RE: Boundary Line Adjustment (BL-26-00007) – Deemed Incomplete – Request for Additional Information

Kittitas County Community Development Services (CDS) received your Boundary Line Adjustment application (BL-26-00007 Flying A Land LLC) on May 7, 2026, for Parcels 954482, 954483, 962344, and 962345. Staff has reviewed your application and determined that more information is needed before this application can be processed any further. As such, Kittitas County declares your application **incomplete** as of June 1, 2026.

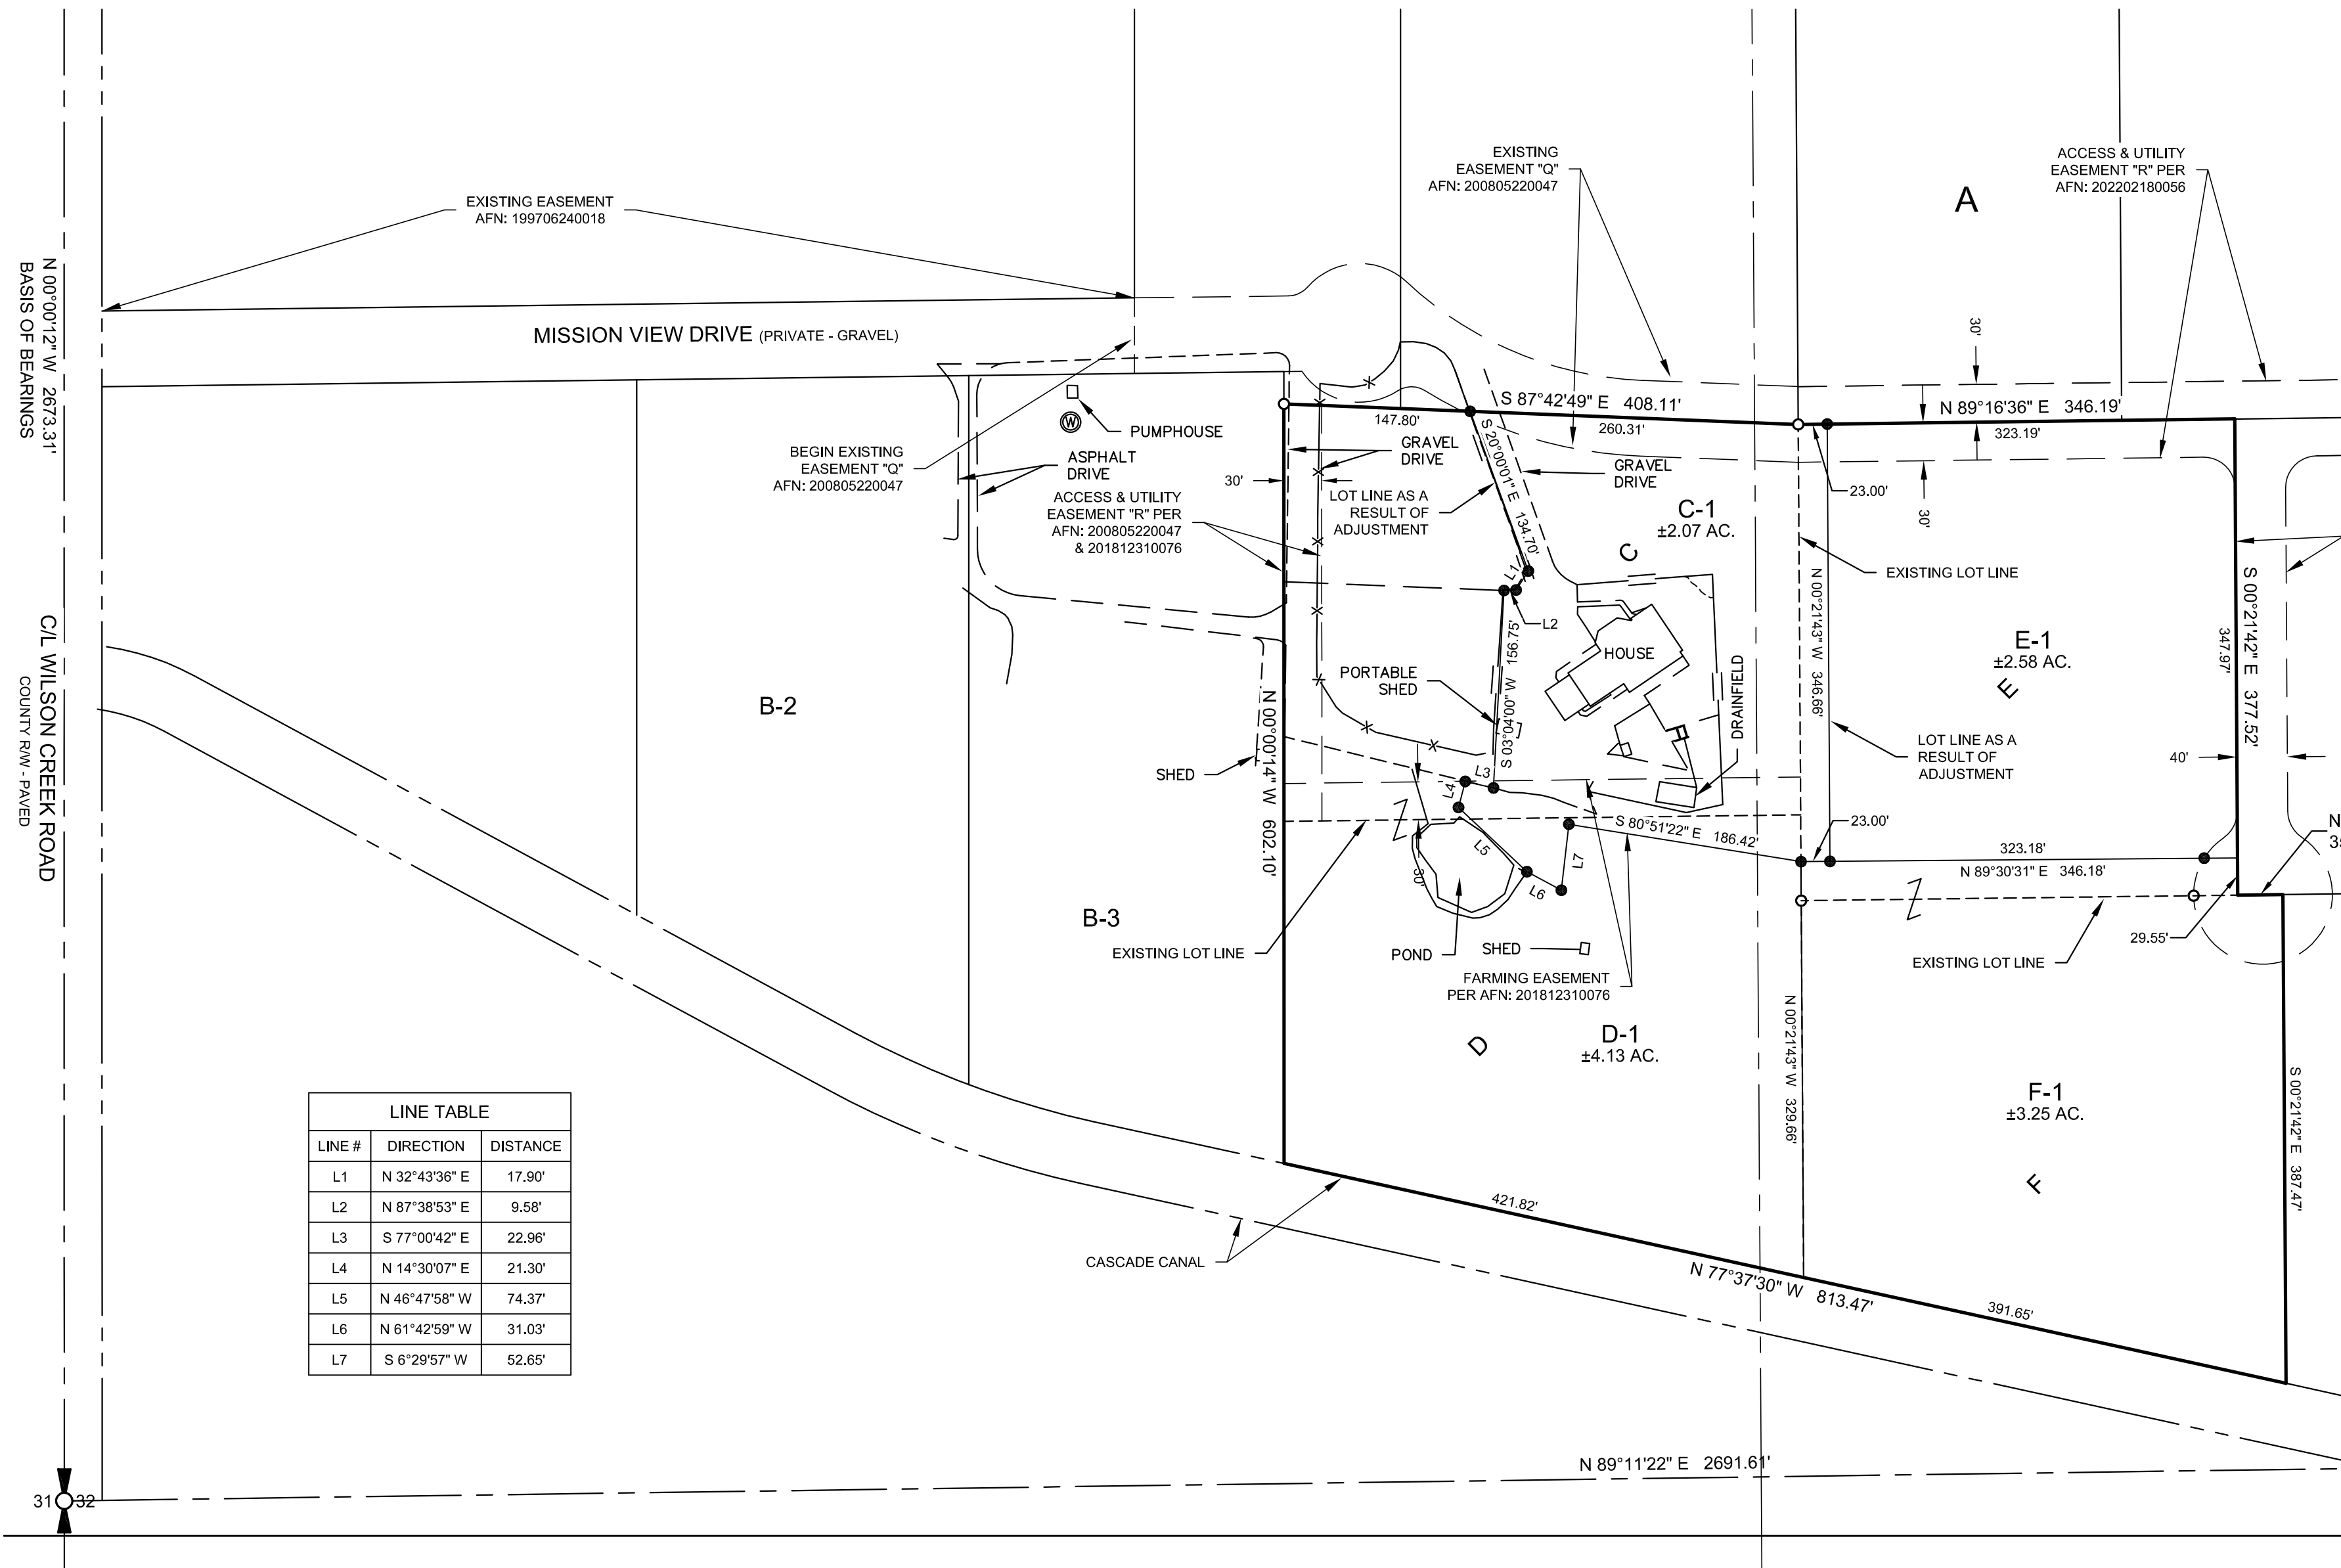
1. The distance from the Western proposed property line on proposed Lot C-1 to the Shed that is identified as being on-site. Per the Required Attachments listed on the cover of the Boundary Line Adjustment application: "Unified site plan of existing lot lines and proposed lot lines with distances of all existing structures..."
